**Our ref:** Q210286  
**Your ref:** PP-12881439  
**Email:** johnathan.welton@quod.com  
**Date:** 12 March 2024

### **Axis J9, Phase 3 – Non-Material Amendment**

On behalf of Albion Land (“the Applicant”), please find enclosed an application for a Non-Material Amendment (NMA) to planning permission 21/03177/F at Axis J9 (“the Site”). The application seeks to vary the list of approved plans set out in Condition 2 to alter Unit 4’s loading door arrangements to accommodate the operations of the intended occupiers. Amendments are sought to amend the gate details of Units 4 & 5, and amend the colour of paving alongside the access road. Amendments are therefore required to conditions 24, 25 and 26 to reflect the updated Site Finishes Plan.

Drawing No: 20019 - TP - 009 Rev: E

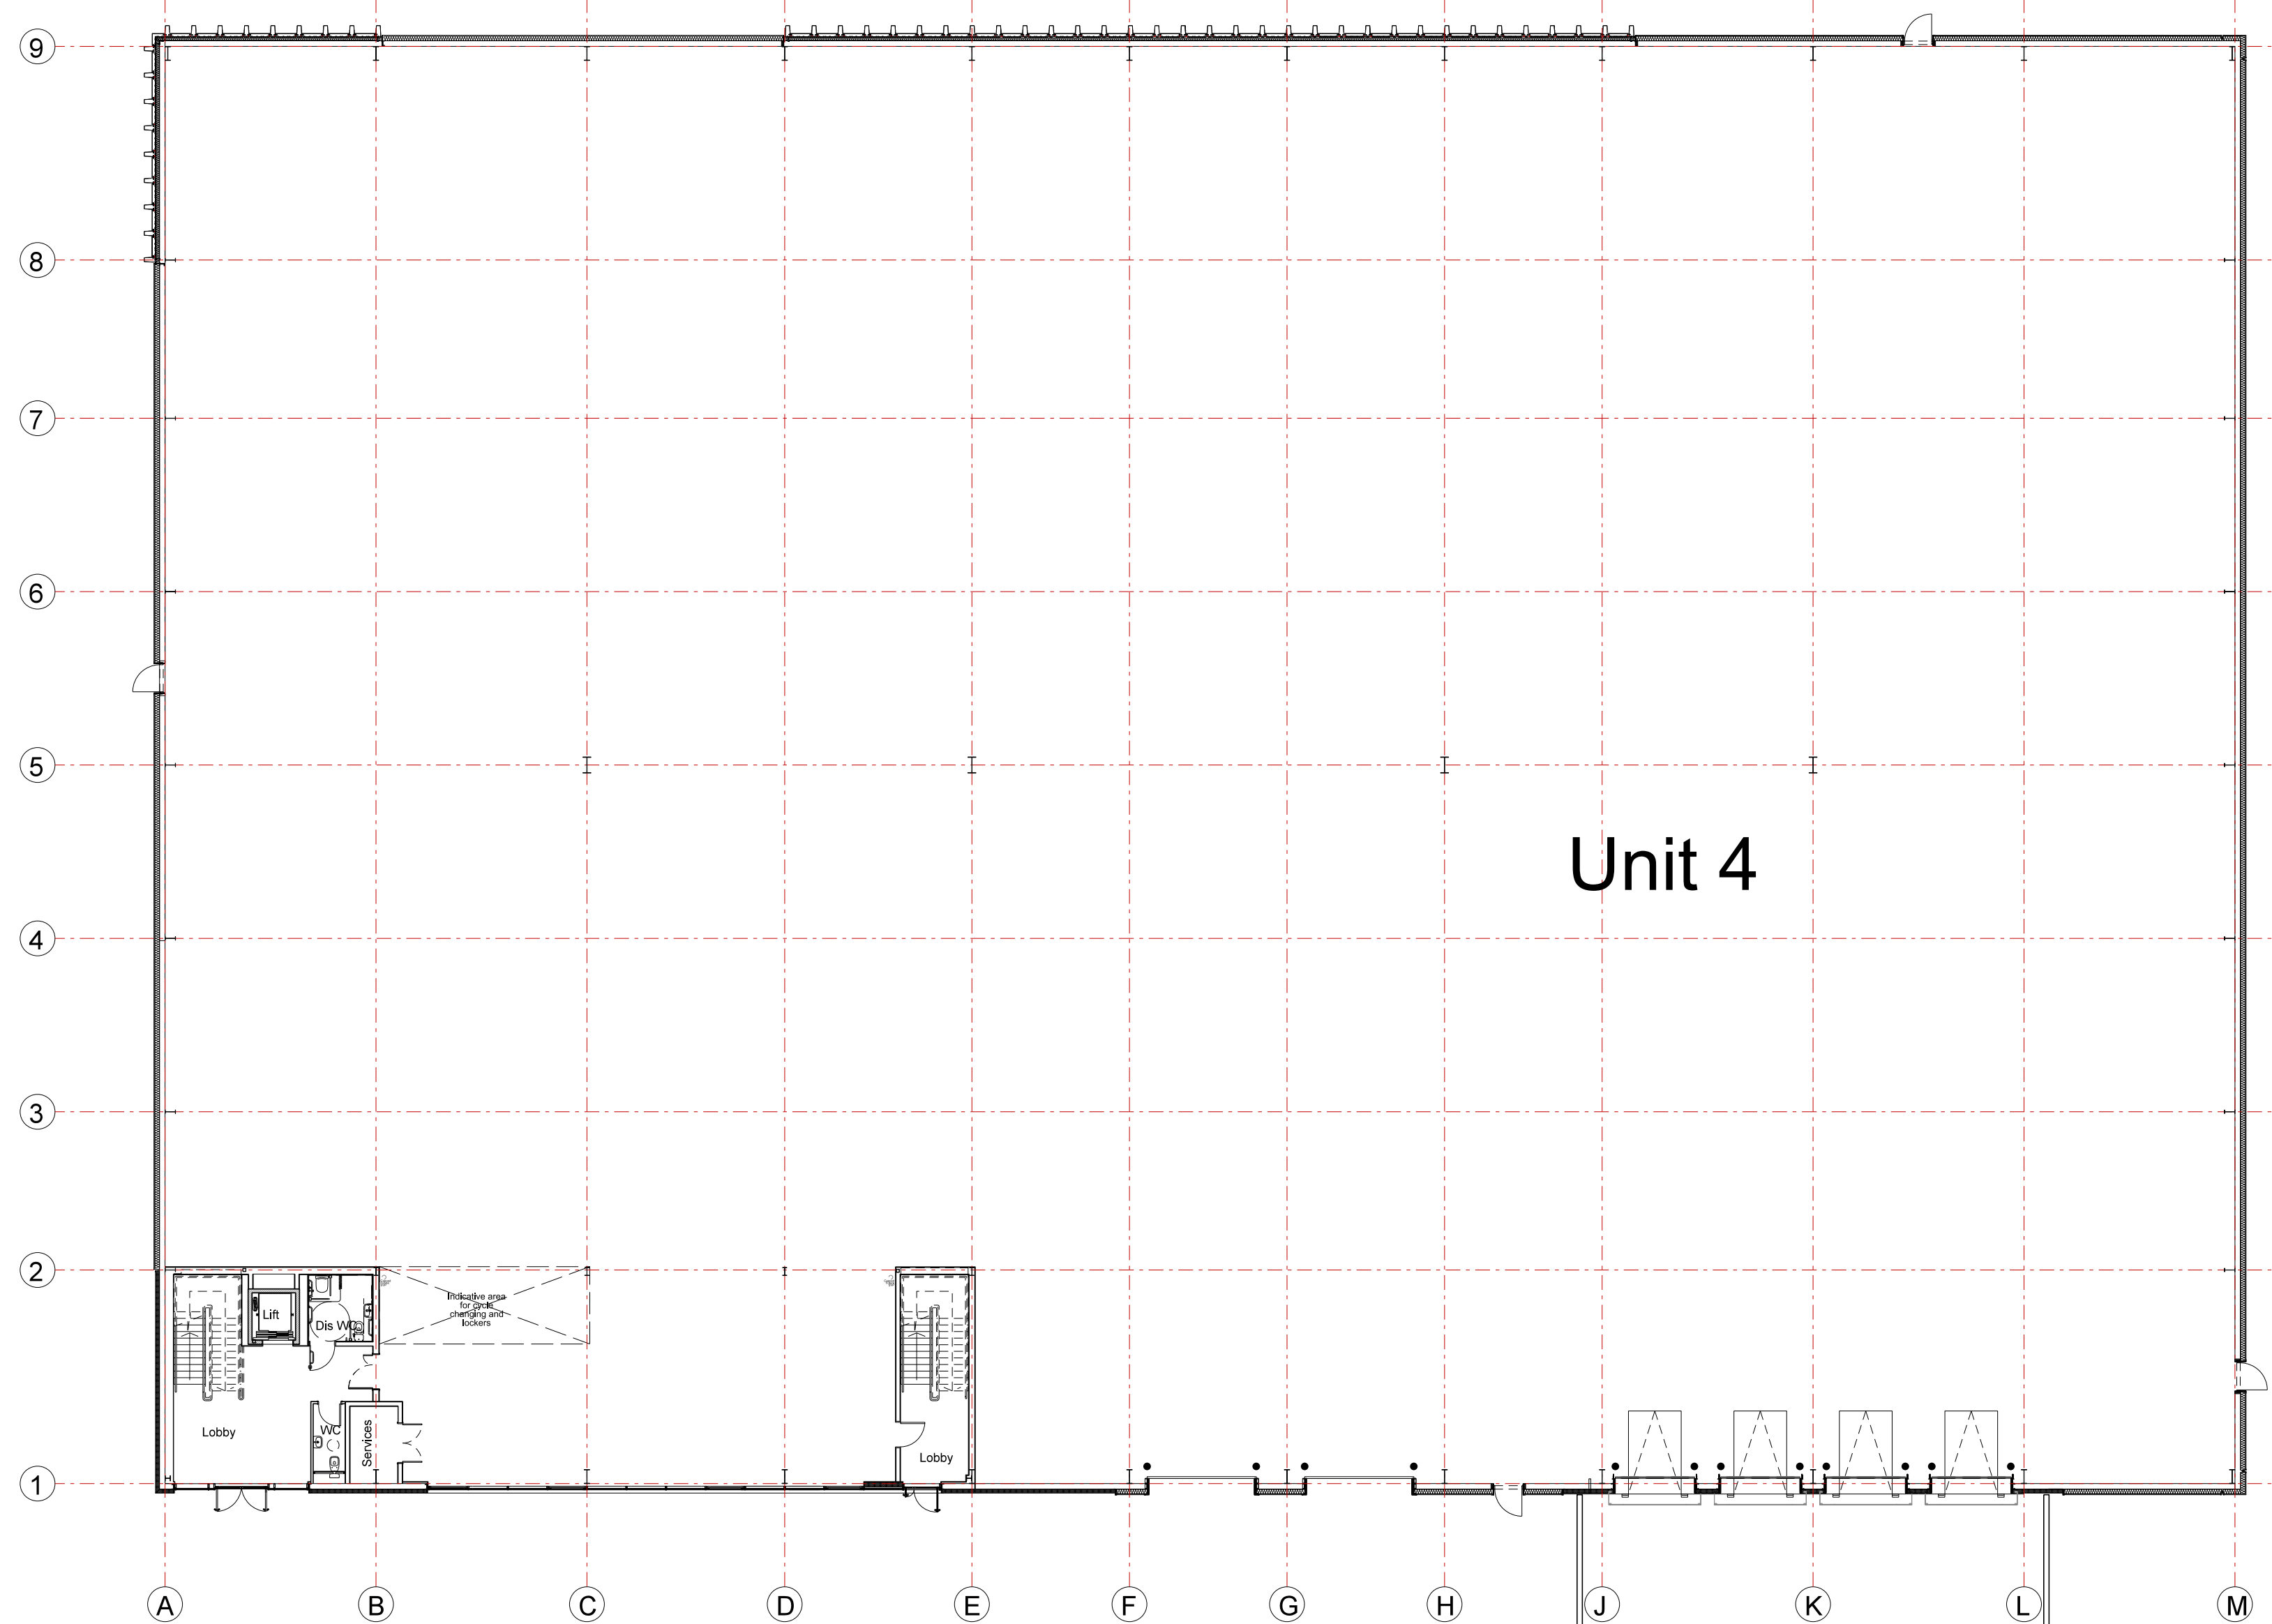
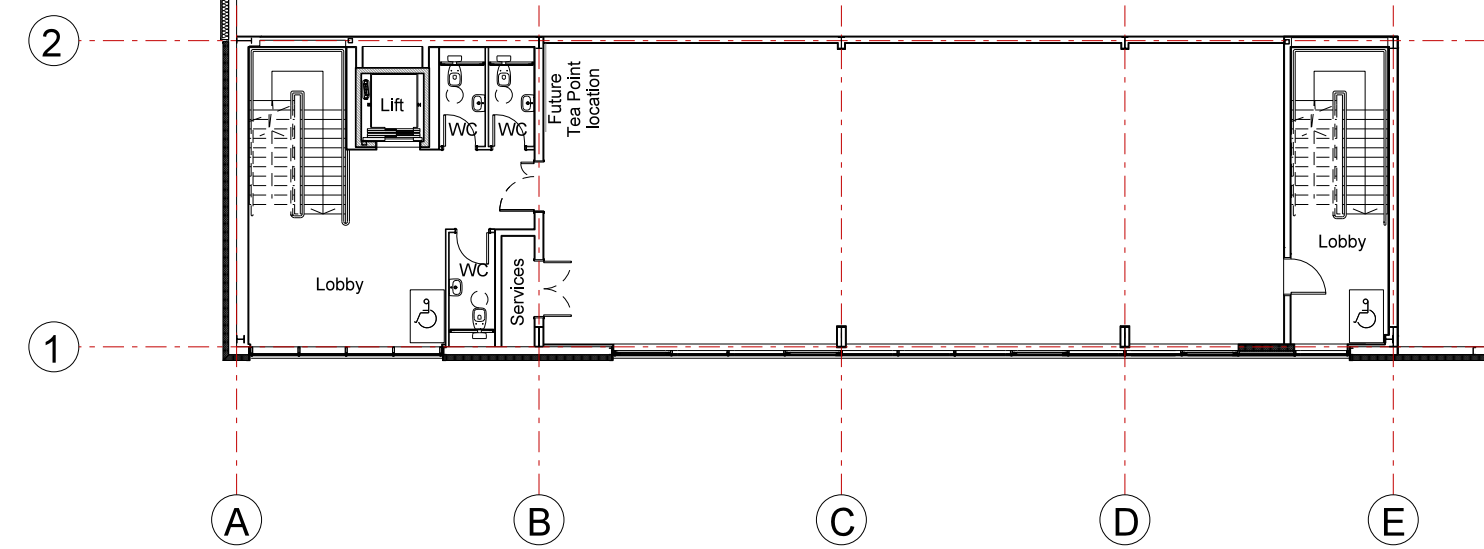
A non-material amendment to the permission was approved in May 2023 (LPA reference 23/01205/NMA) for the variation of Condition 2, 24, 25 and 26. The changes approved via that NMA also related to loading arrangements for Unit 4, which had been tailored to another prospective occupier. The approved plans show five level loading bays and one loading door. The proposed plans show four loading bays and two loading doors.

20019-TP-012 Rev E Unit 4 Elevations	20019-TP Rev F Unit 4 Elevations	Updated to show new loading arrangements.
20019-TP-025 Typical Canopy Details	20019-TP-025 Rev A Typical Canopy Details	Updated to remove reference to units 6-11 (which are not part of the approved development) and replaced with Units 1-3.
20019-TP-025 Fencing Details	20019-TP-025 Rev A Fencing Details	Details of entrance to Units 4 & 5 amended to swinging gates.

Drawing No: **20019 - TP - 025** Rev: **A**

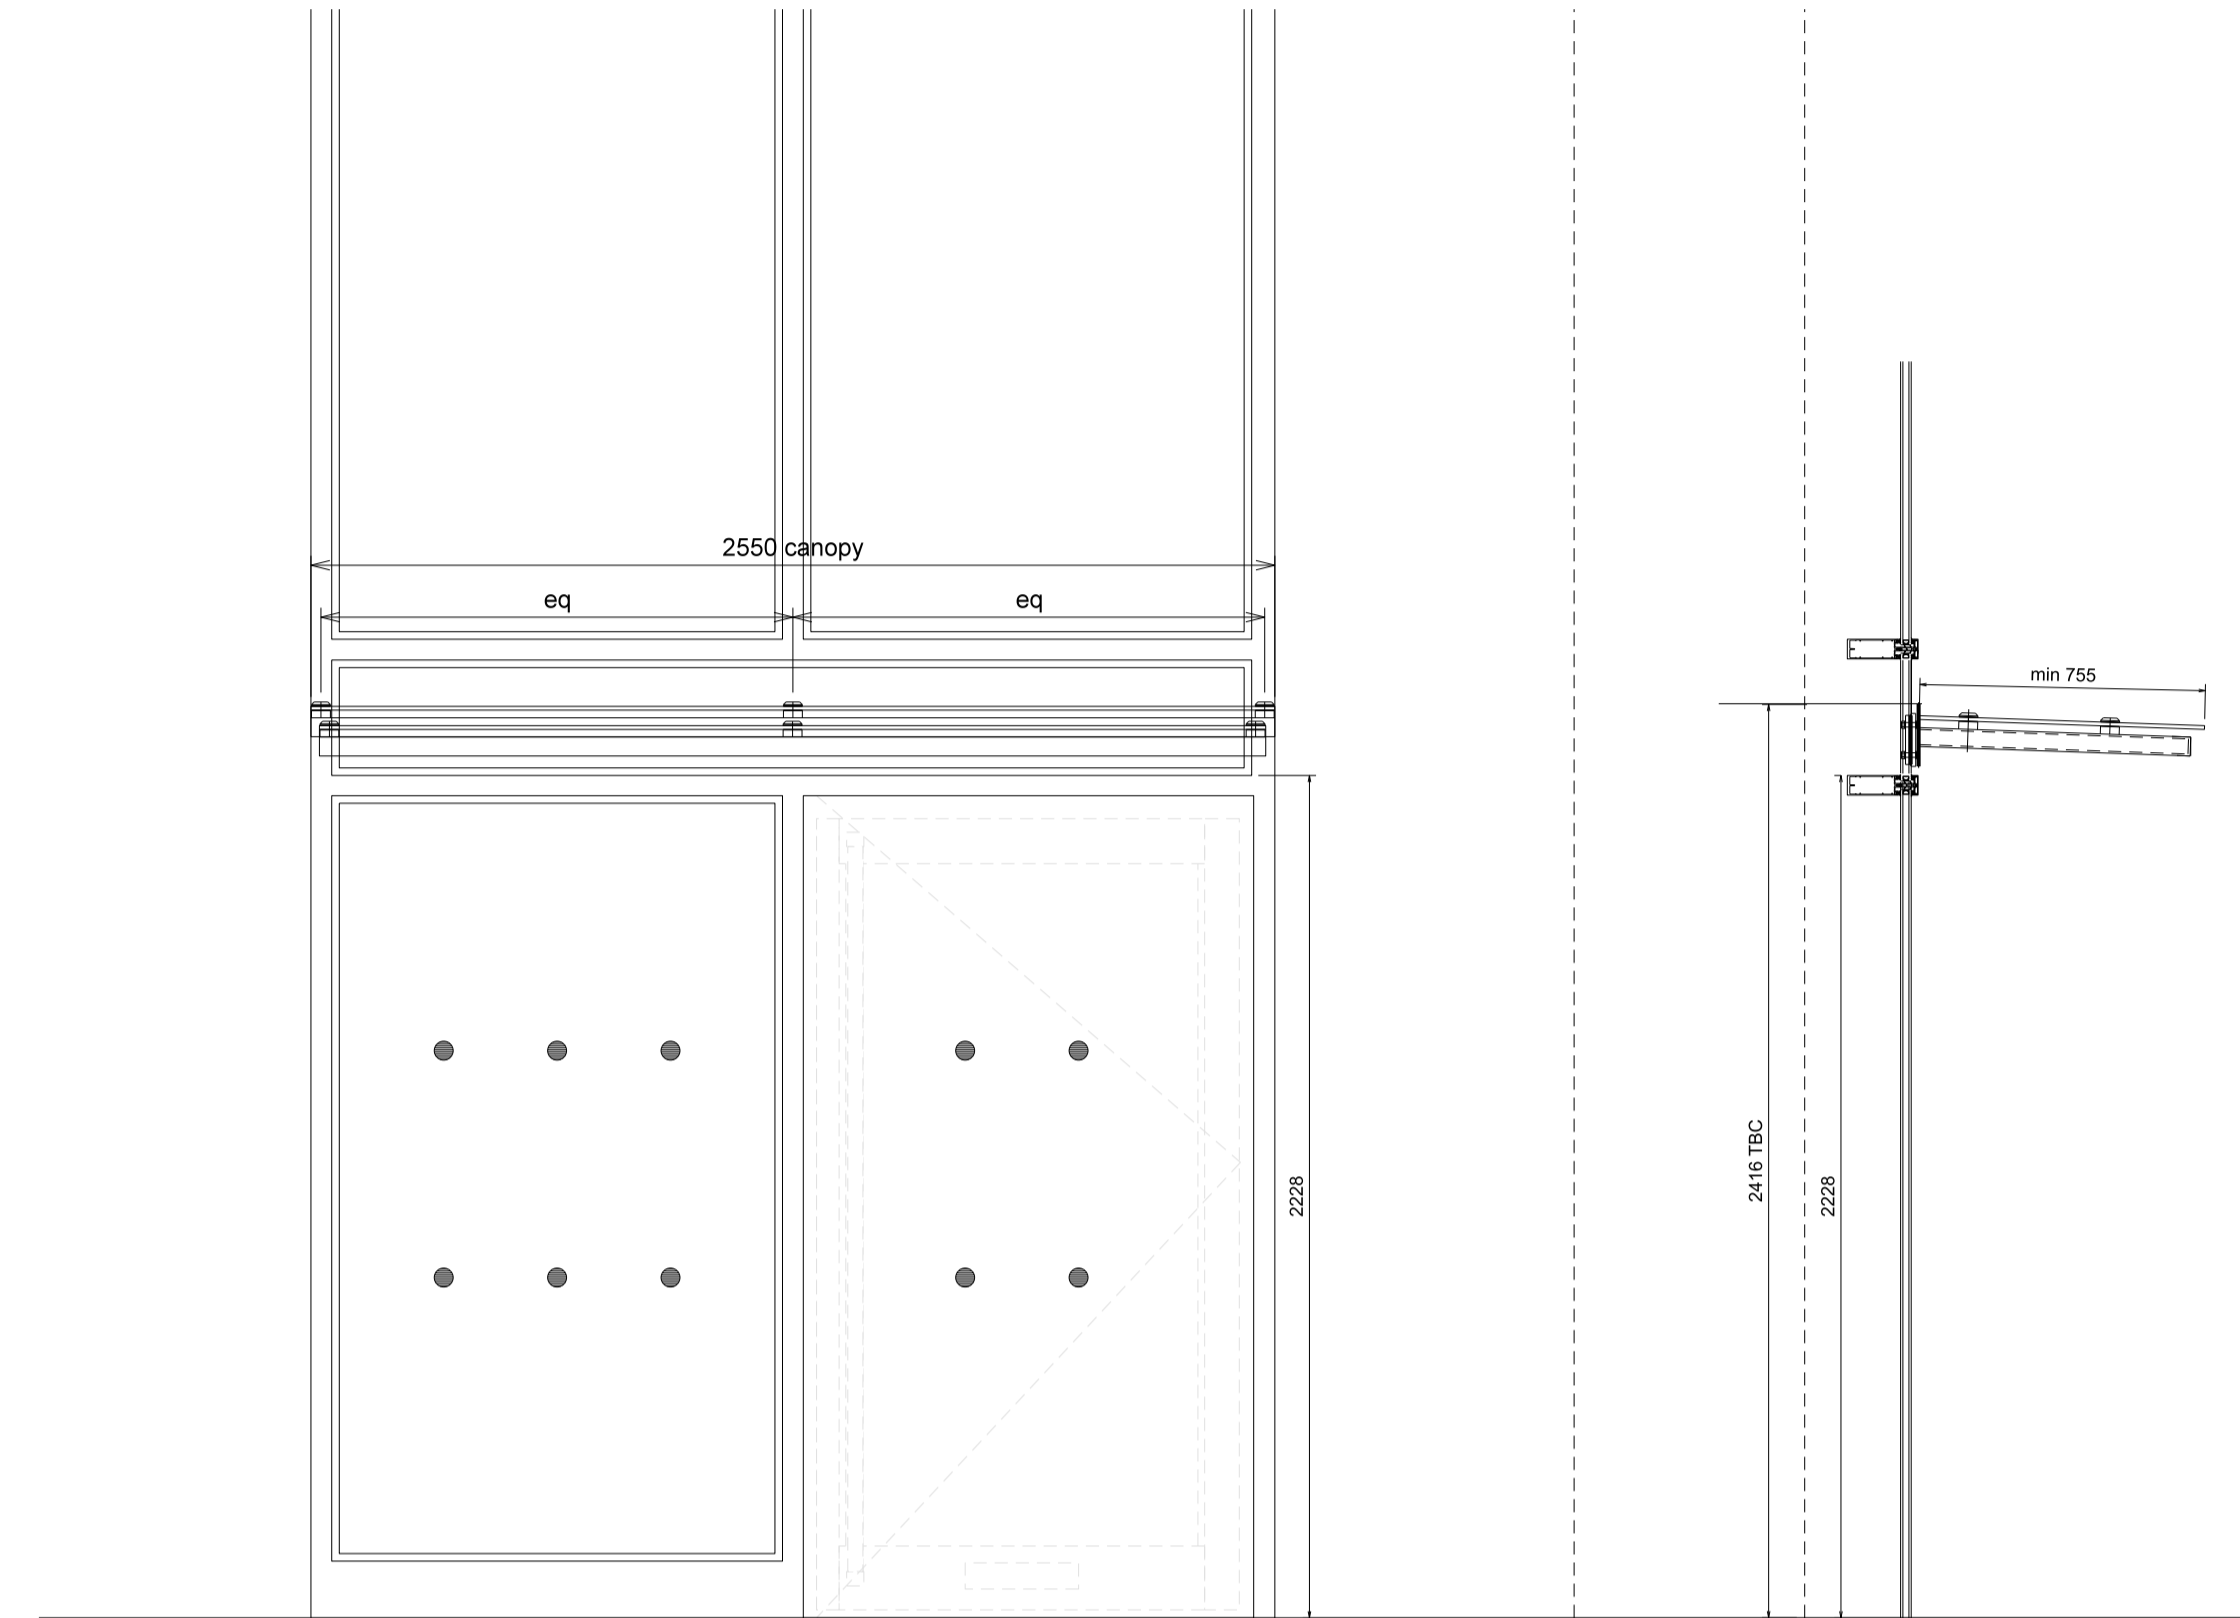
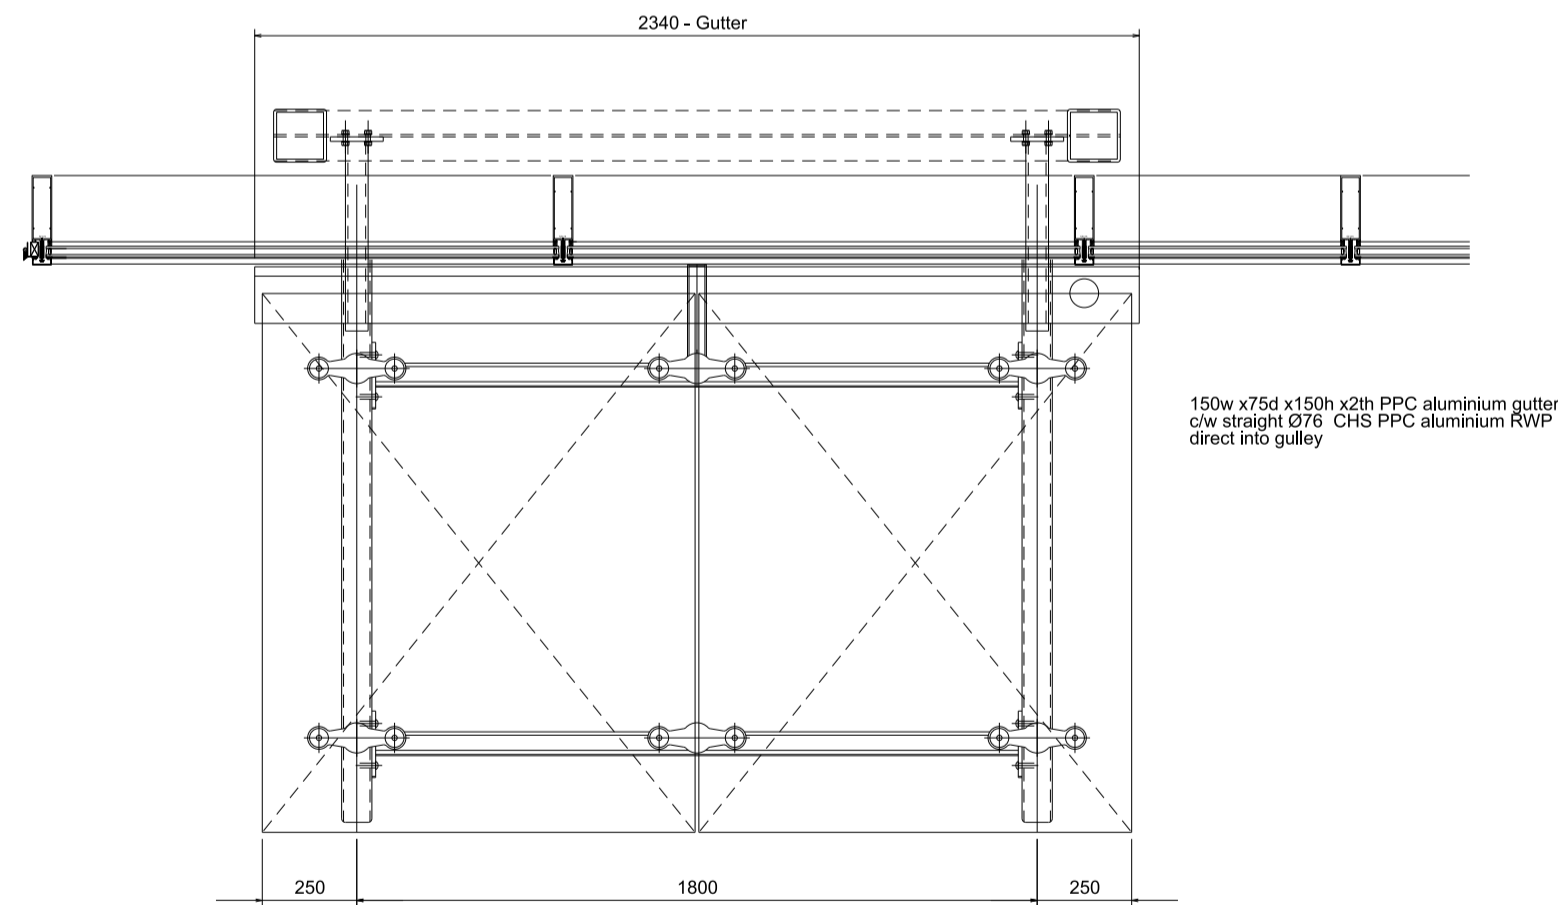
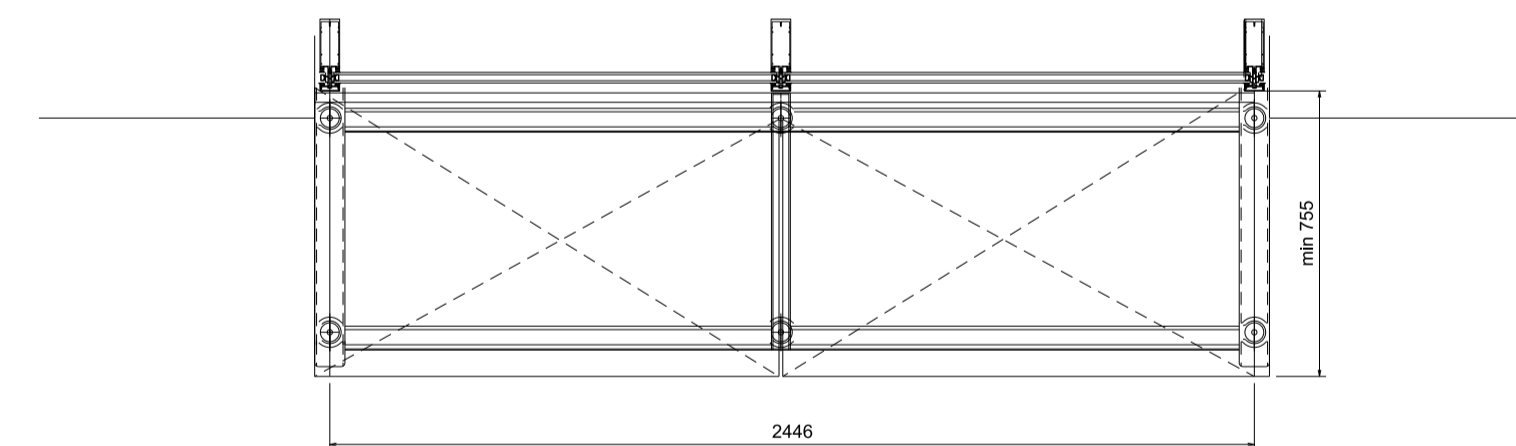
Minor changes are proposed to alter the colour of paving to match previous phases of development at Axis J9. The proposals also clarify the canopy details for the relevant units.
